**Planning Department
Transportation Development Services**

January 7, 2016

**Re: Heritage Market Place
1820 Unser Blvd., NW
Request for Temporary Certificate of Occupancy- Transportation
Development
Engineer's/Architect's Stamp dated 4-9-15 (H09-D024)
Certification dated 1-04-15/6**

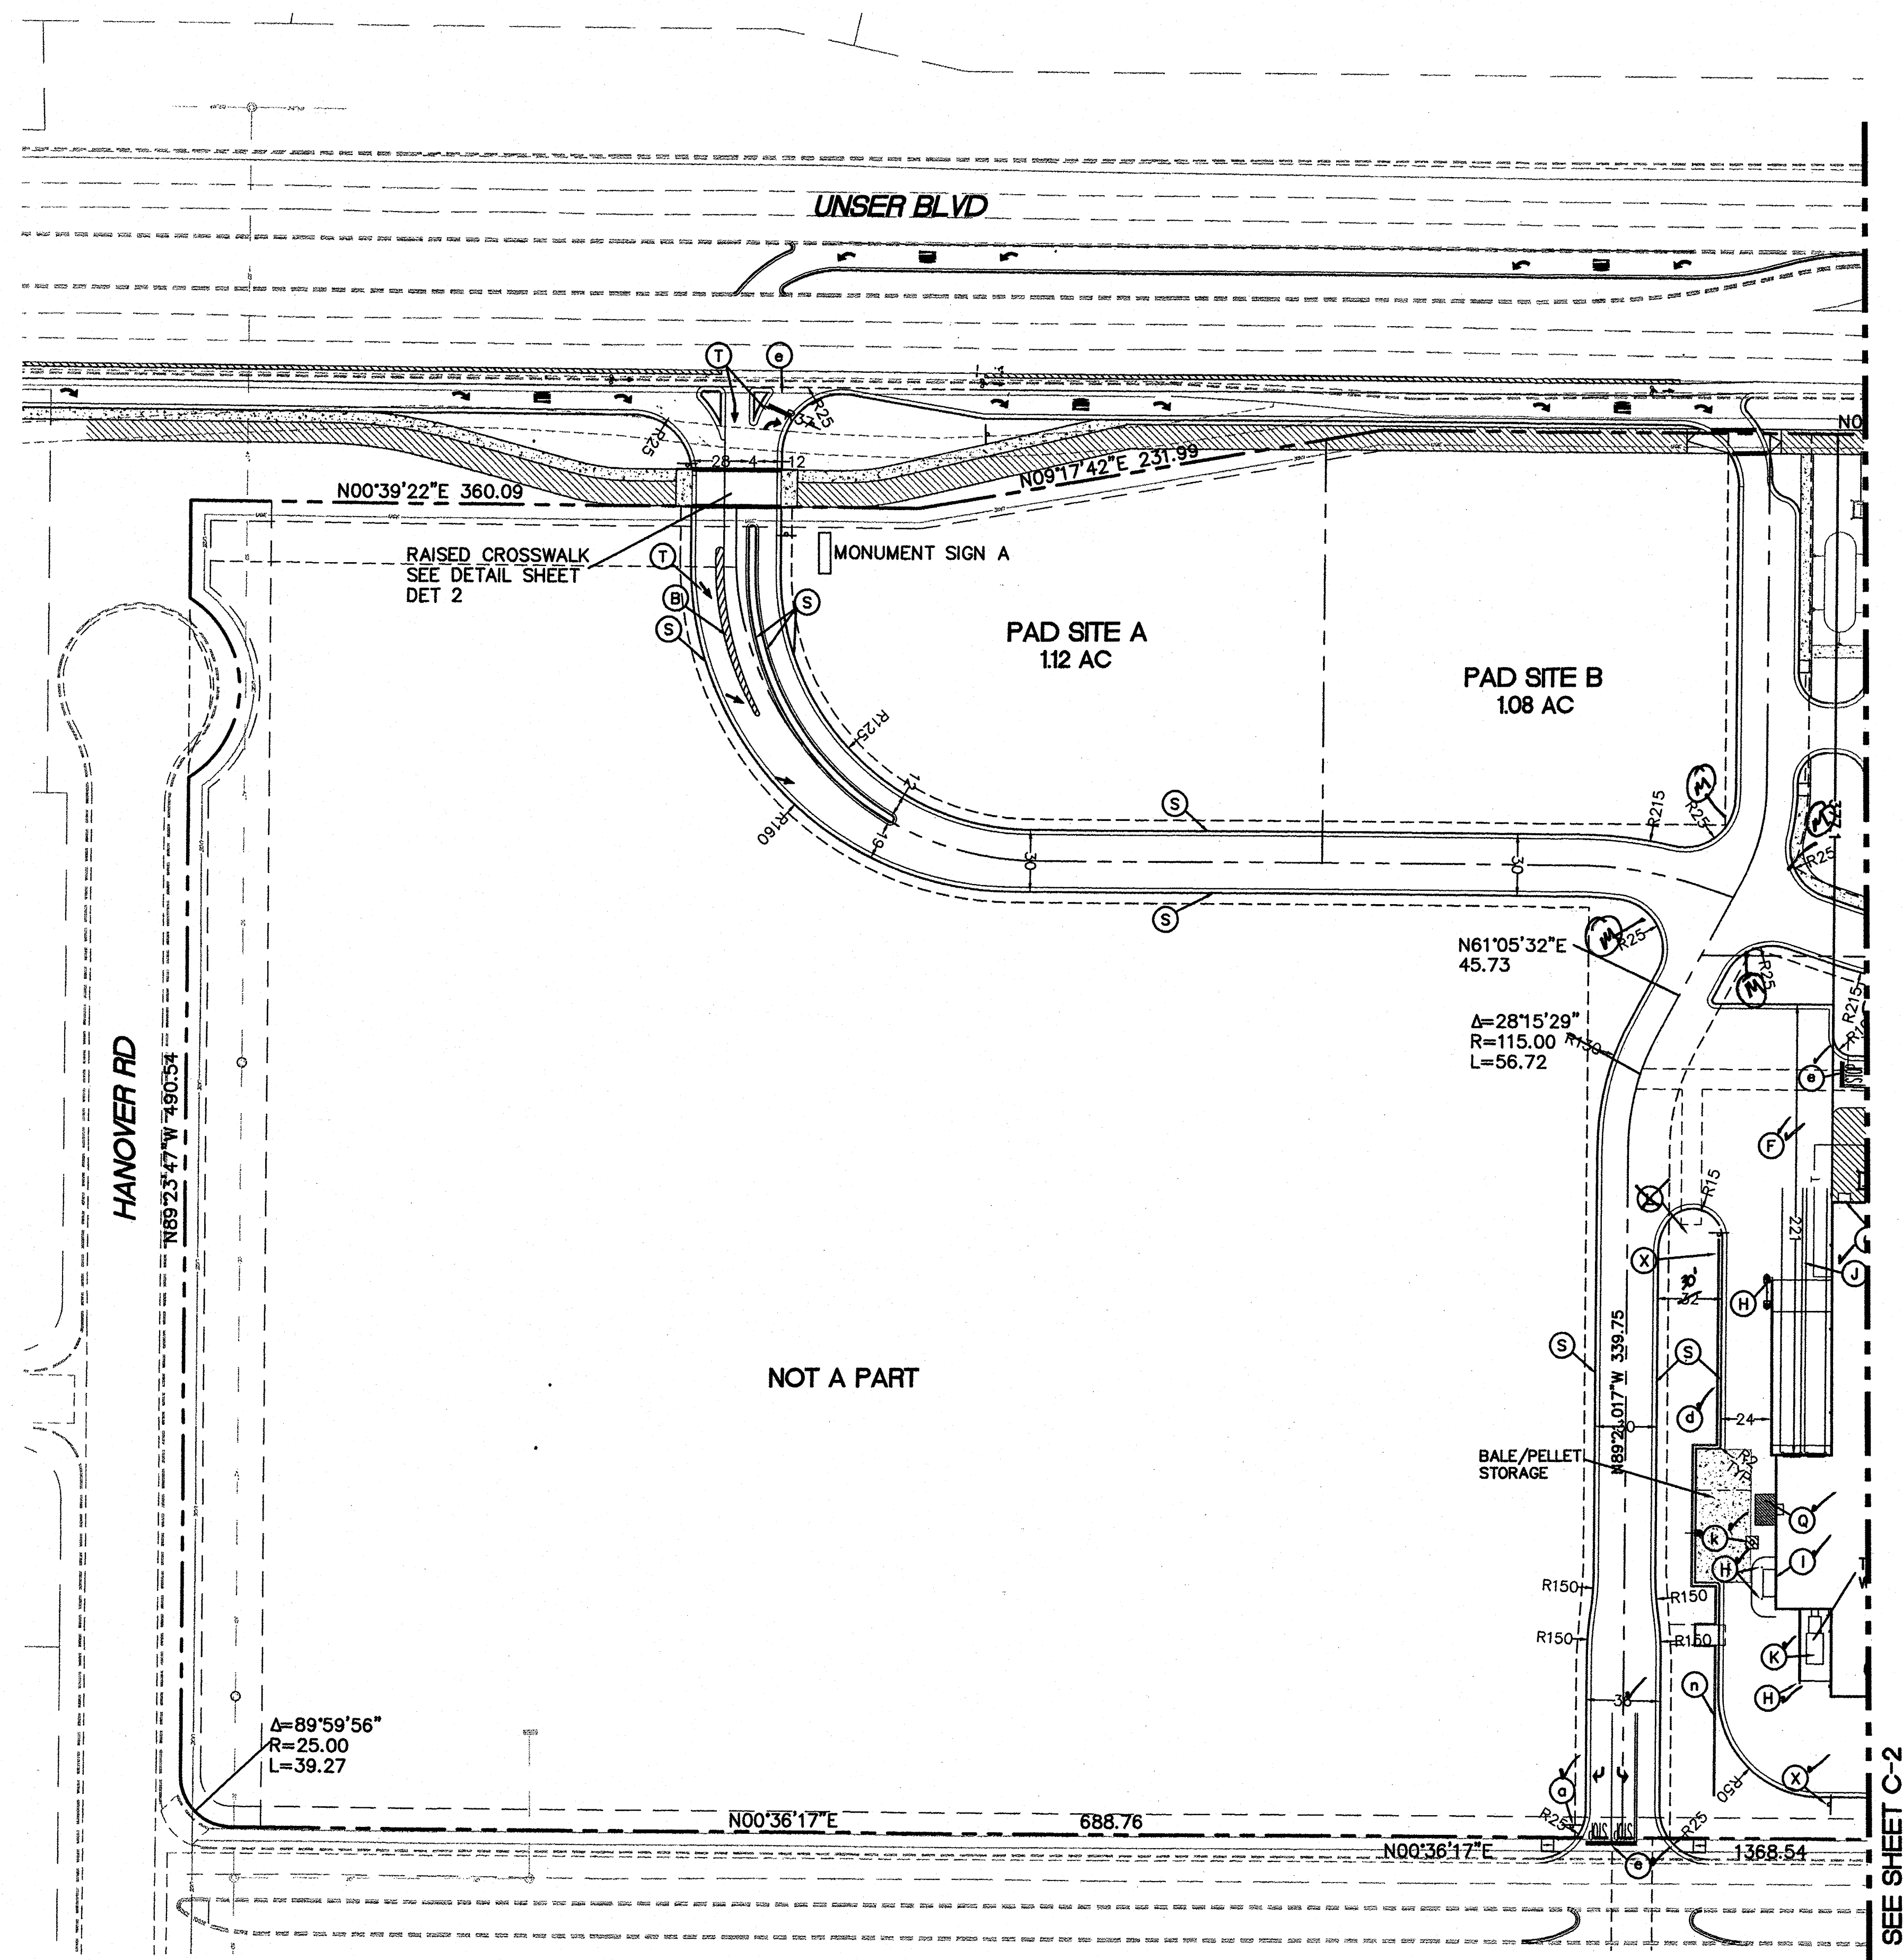
1. Add Stop signs at interior 4-Way intersection south west of the building.
2. Truncated domes along all public Right of Ways need to be installed.
3. ADA parking spaces do not meet number of required spaces. ADA pavement between ADA parking spaces needs to be marked with cross hatching.
4. Motorcycle parking is missing and required.
5. Additional signage and striping is required to prevent left hand turns at the shopping center exit located approximately 500 ft. south of Ladera Blvd. on Market Street.
6. "No Trucks" sign Key Note "K" needs to be installed at the eastern entrance.
7. Painted "Yield" on pavement on the north side of store needs to be repainted, due to discoloration.
8. Work Order must be complete and accepted prior to final C.O.
